Engineers Comments Regarding Surface Water Drainage

Application Reference:	M/40/26/PL	Reviewer Reference:	ADC/EXT5/AF
Planning Officer:	Kathryn Welch	Date of Review:	24/09/2026
Site Name:	Arundel Court 47 Elmer Road Middleton-on-sea PO22 6LB		
Application Description:	Two storey rear extension to enlarge existing flats and additional second floor to building to create an additional 2No. 2 Bed flats giving an overall total of 6No. 2 Bed flats. 6No. parking spaces to the rear consisting of a 3 car garage block and 3 parking bays and associated hardscaping. This application is in CIL zone 4 (zero rated) as flats.		
Assessment Number:	2

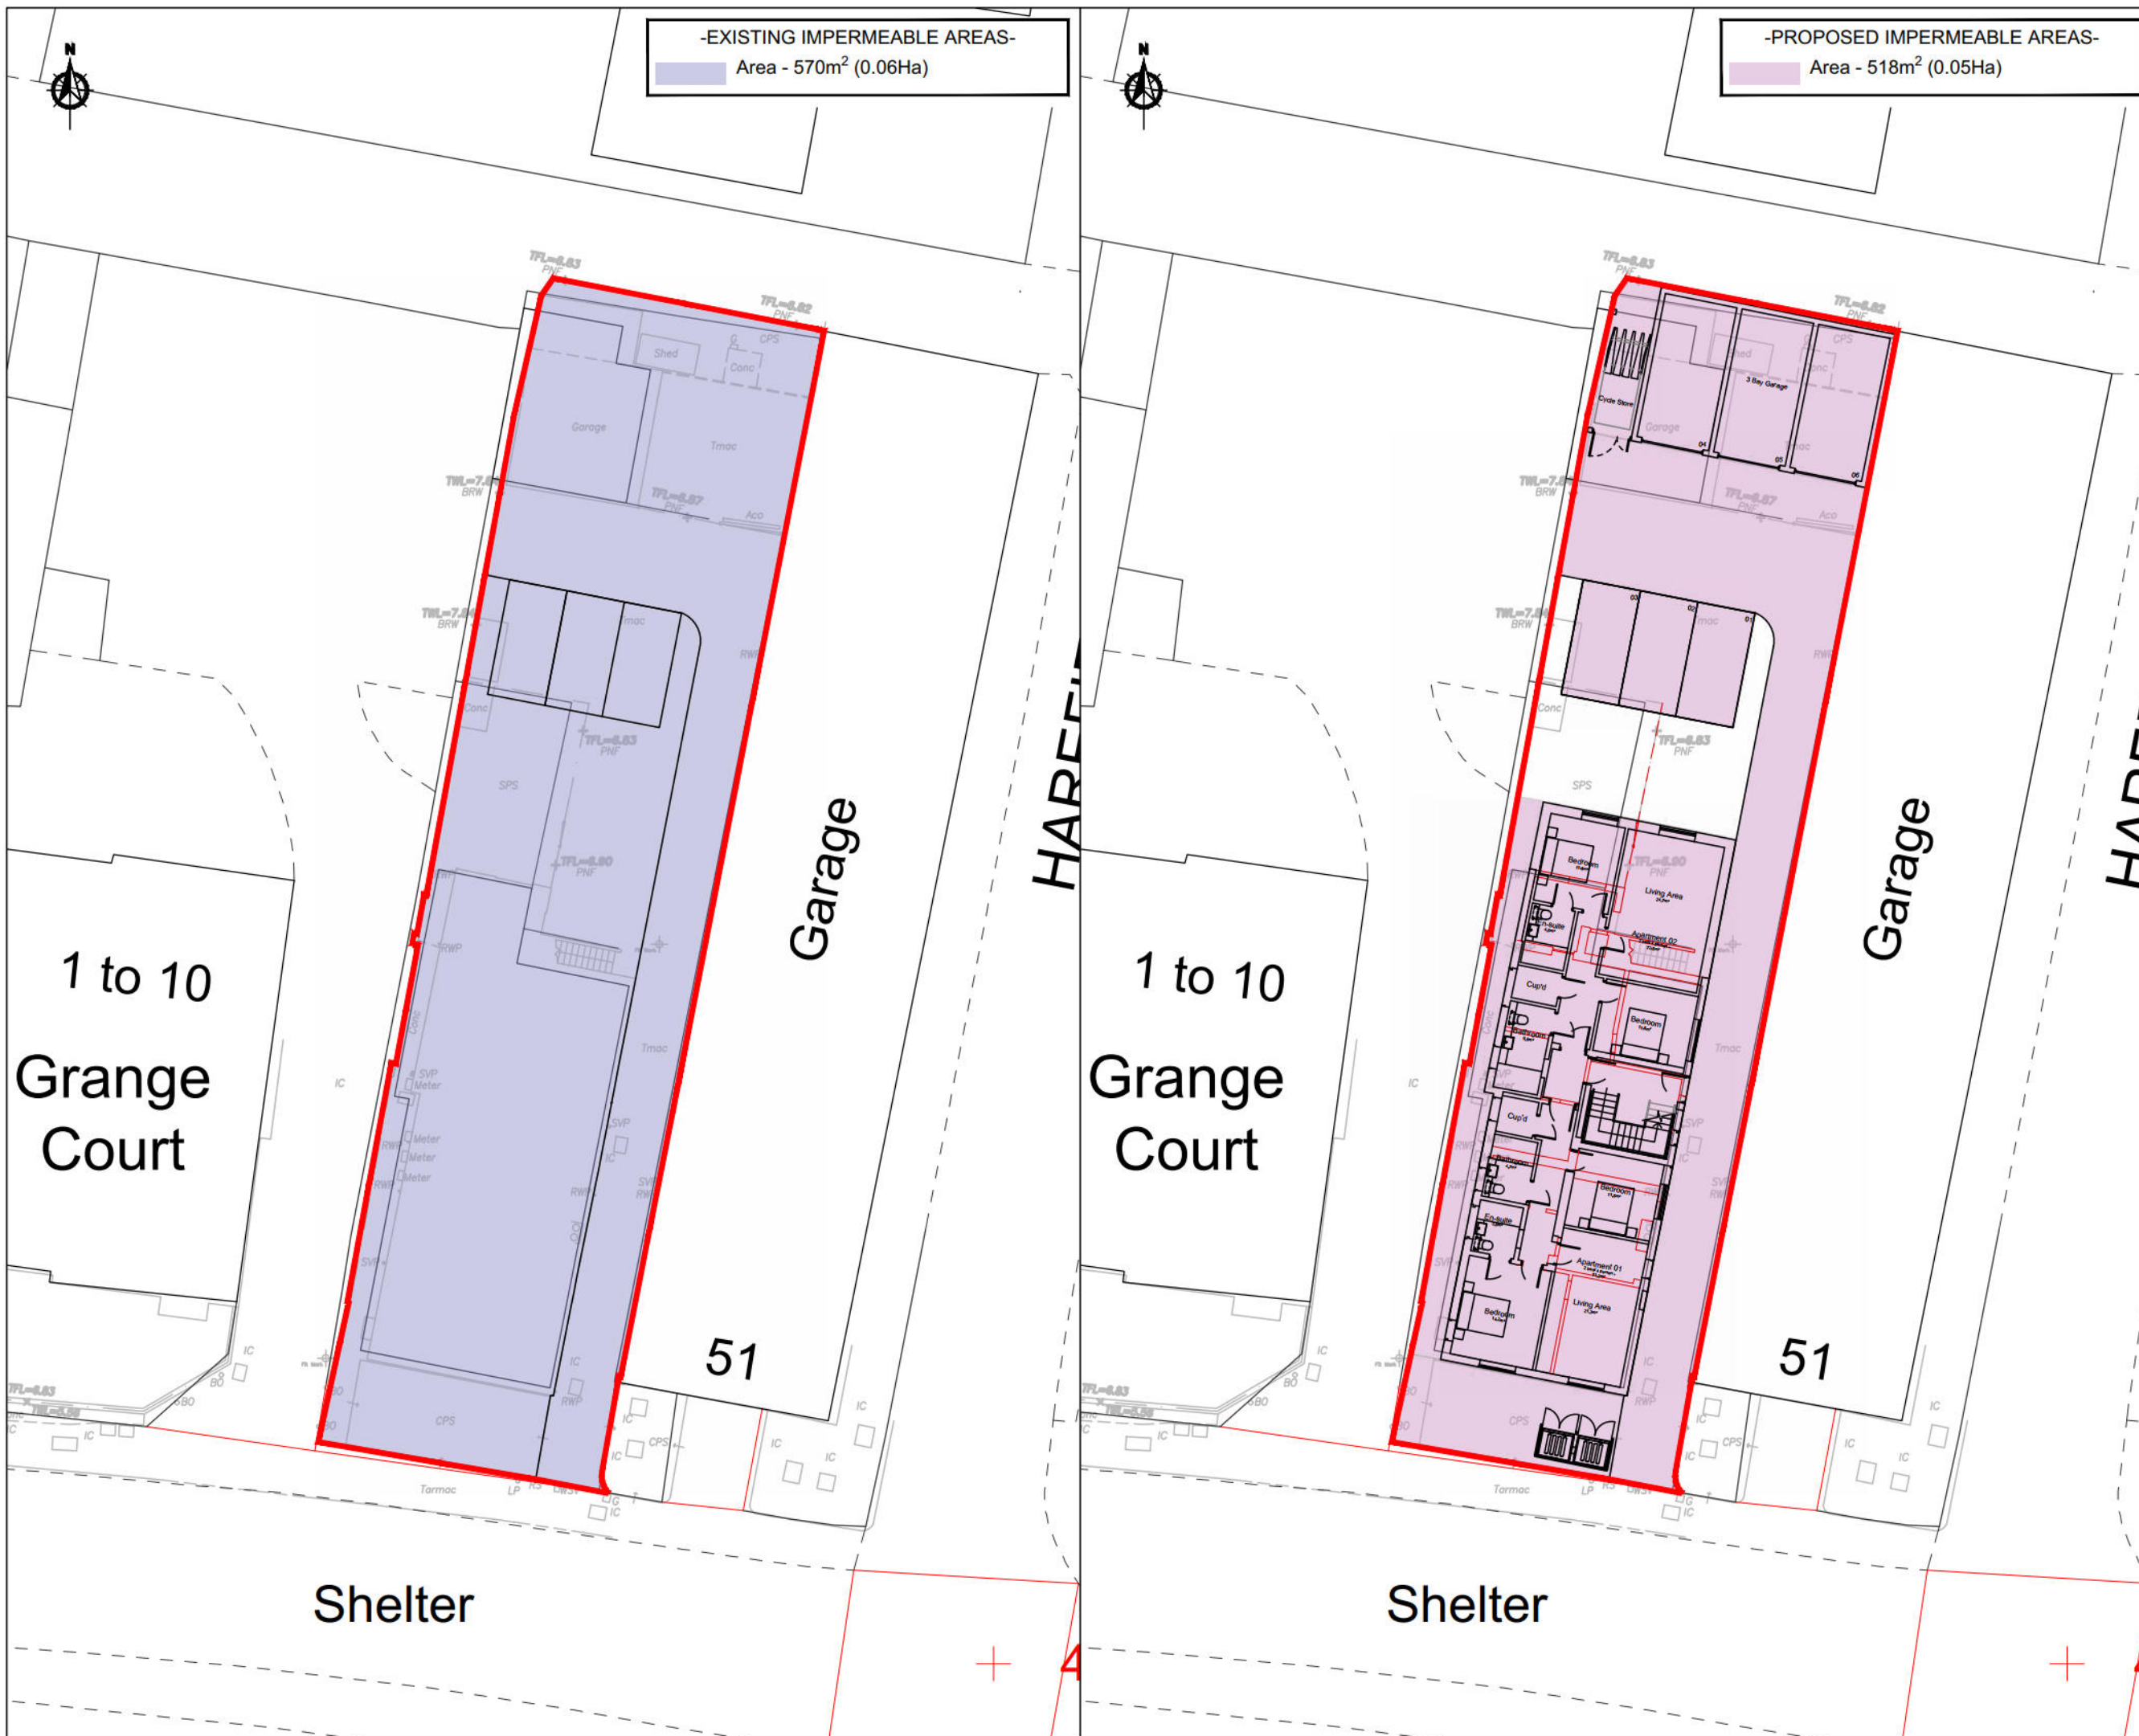
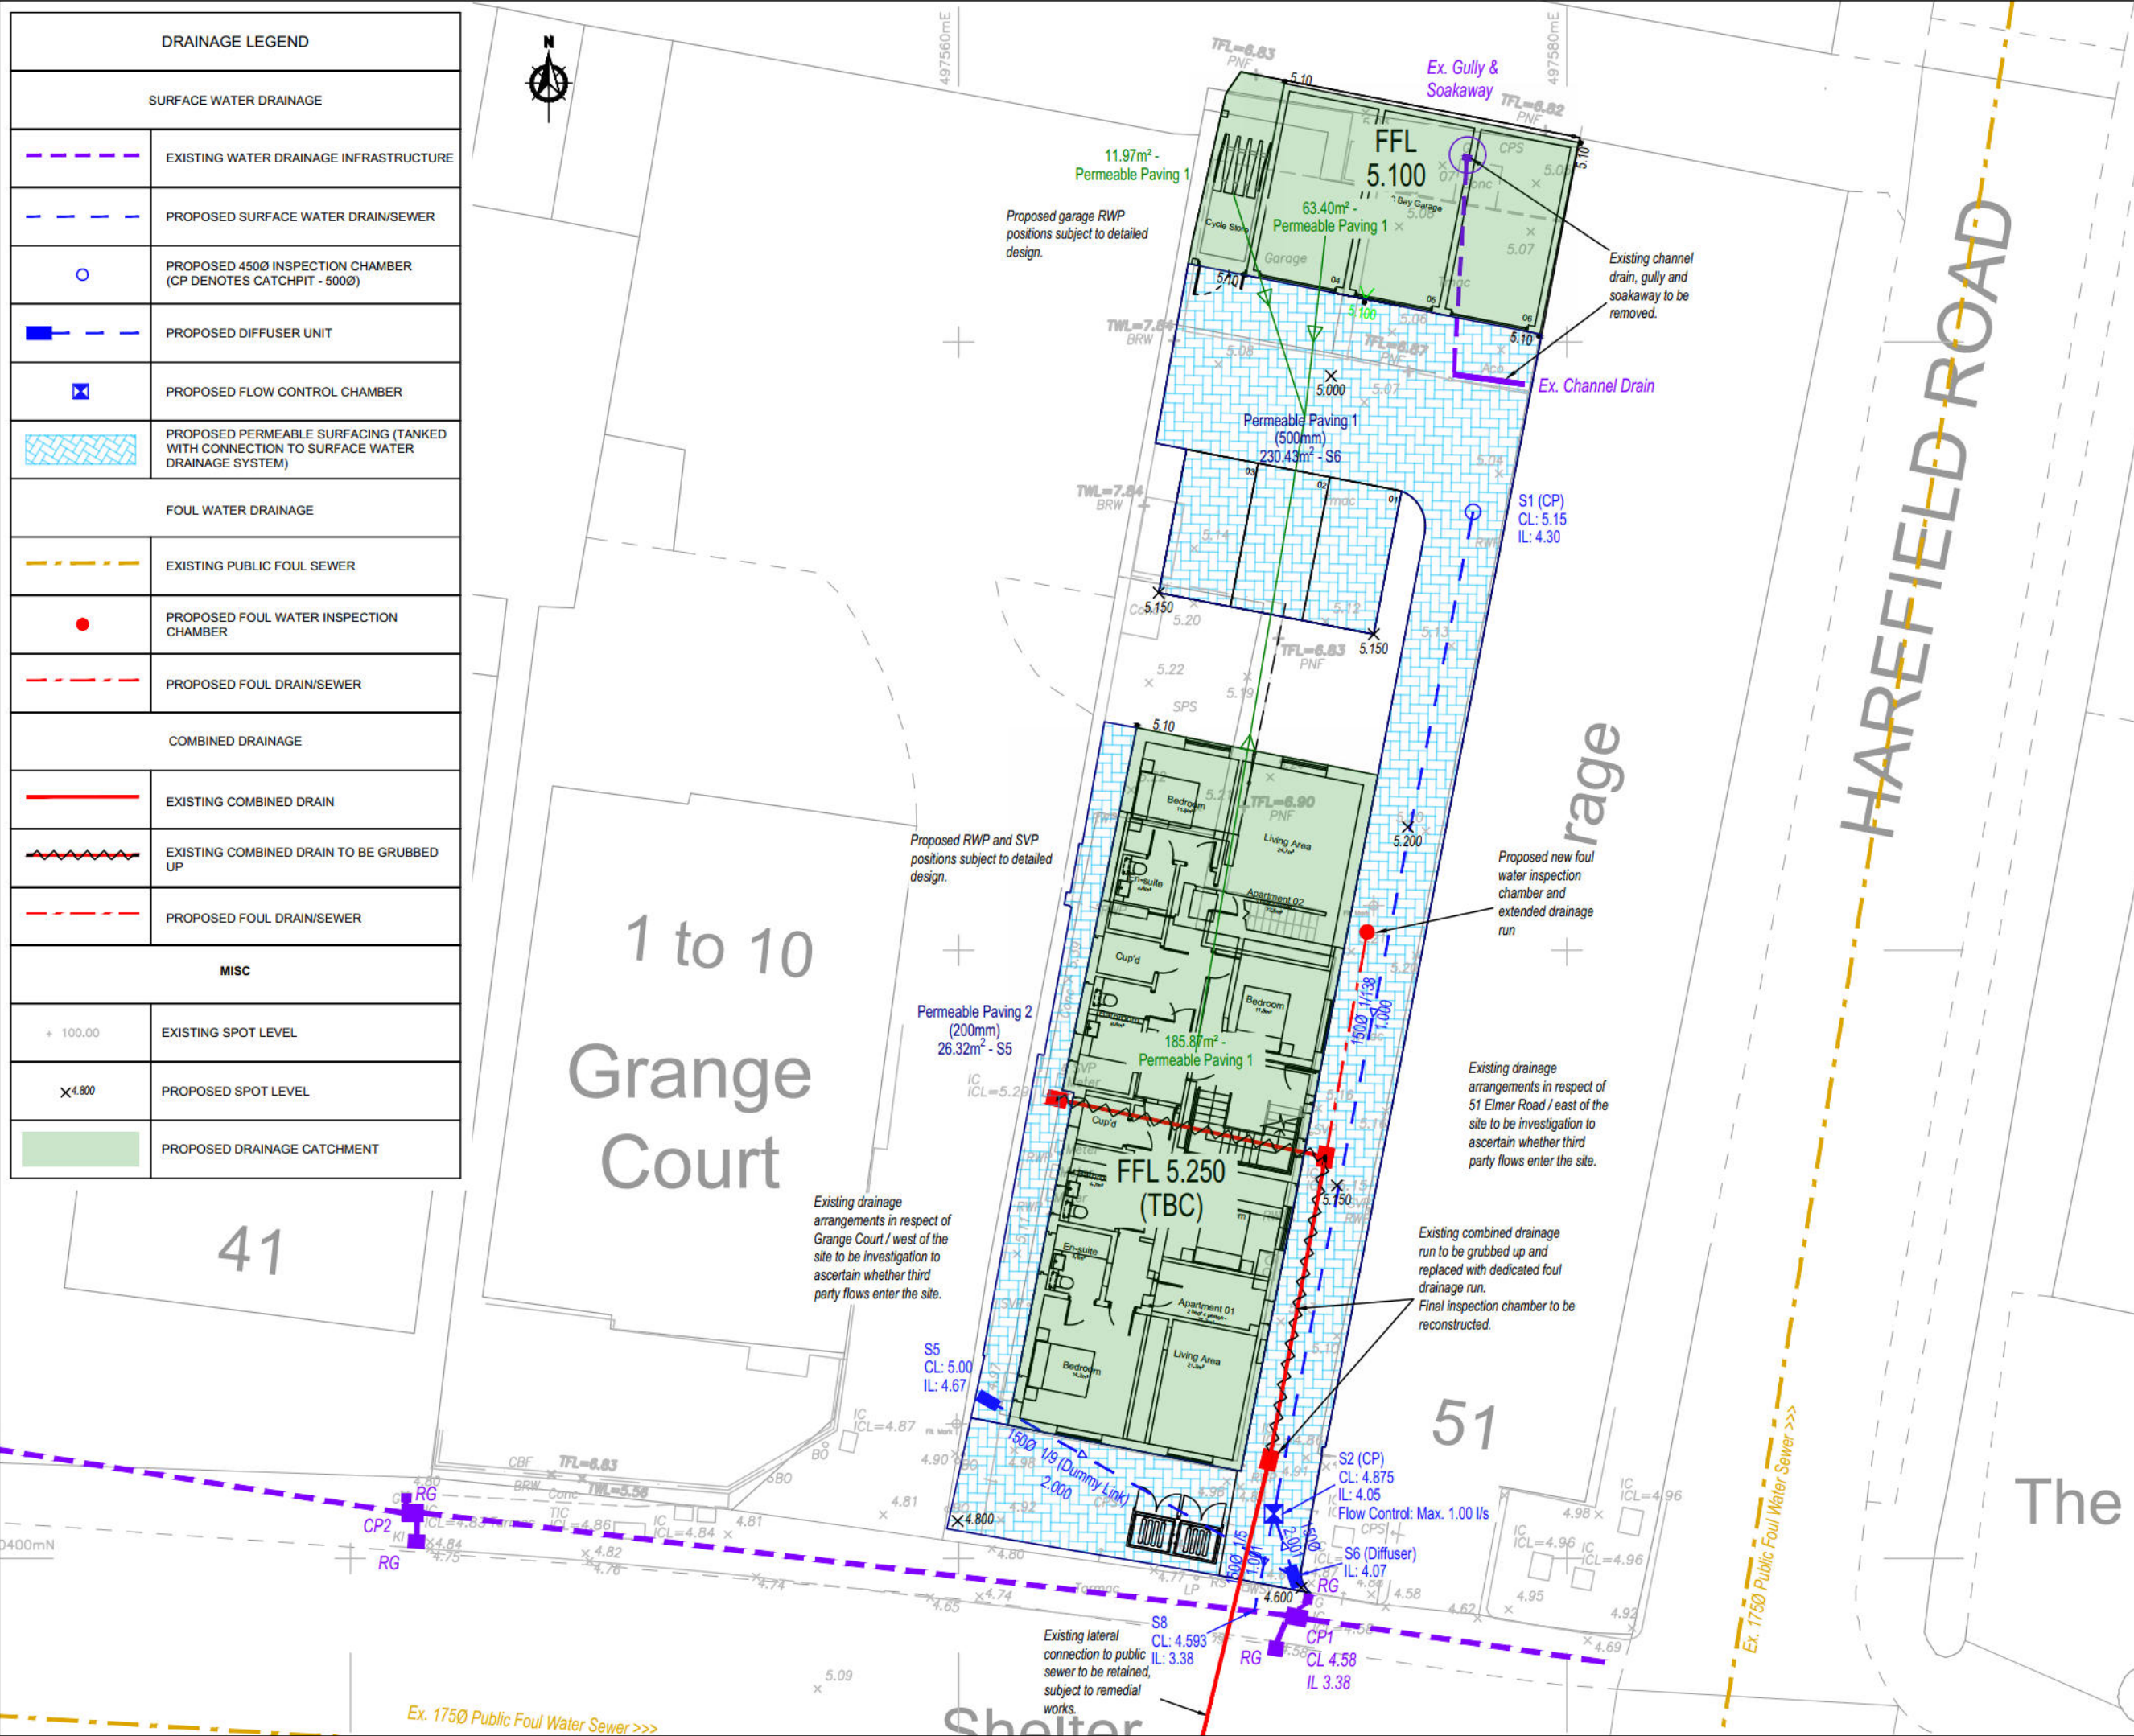
- 1.4. The proposed drainage strategy is to make a new connection to a highway drain. This will require the approval of the Local Highway Authority as asset owner. An indication of acceptance is received from West Sussex County Council sufficient for planning stage. This indicates the connection should be made to the chamber and not the pipe as currently shown. More formal approval can be provided at discharge of conditions stage.

- 2.1. Permeable paving is proposed for the external paved surfaces which is permissible for the self-drained area of the permeable pavement.
- 2.2. The roof areas are not currently served by a separate allocation of interception drainage. There is a note on the drawing indicating SuDS planters but the total size is unknown.

- 3.1. The drainage design incorporates permeable paving as an attenuation blanket upstream of a fixed flow control.
- 3.2. The surface levels of the permeable paving in the area of storage vary by more than the effective depth of the storage. The calculations have now been updated and appear to reflect a sloping

- 3.3. The proposed design peak outflow is 1 litre per second which is based upon a relaxation to 5 times average greenfield runoff rate. The justification for relaxation is not clear and the designer should restrict to greenfield runoff unless it is not feasible to do so. The peak outflow may therefore be higher than necessary, and not in accordance with the NSfS.

- 3.4. The potential to relax the peak flow rate would be due to site constraints. No relaxation has been agreed for this site and the peak flow rate should be the greenfield runoff rate or as close as feasible. There are flow control solutions and blockage protection methods which allow low rates of 0.2 litres per second which could therefore be applied.

- 3.5. A surcharged outlet is now shown in the calculations. However, the basis for the surcharge level set out in the letter report is not robust. The surcharge is only 220mm which implies the highway drain running full-bore but not a surcharged system during a 100 year return period (1% AEP) storm. There is likely to be a surcharged network during the 1% AEP plus climate change design storm with water levels far exceeding top of pipe in the chamber. Particularly considering highway drainage is not designed for a 1% AEP storm. A precautionary approach should be adopted where conditions are not known.

- 3.6. The design to manage extreme rainfall is not currently demonstrated to be in accordance with the requirements of NSfS Standard 3. Therefore, we **object** to the application.
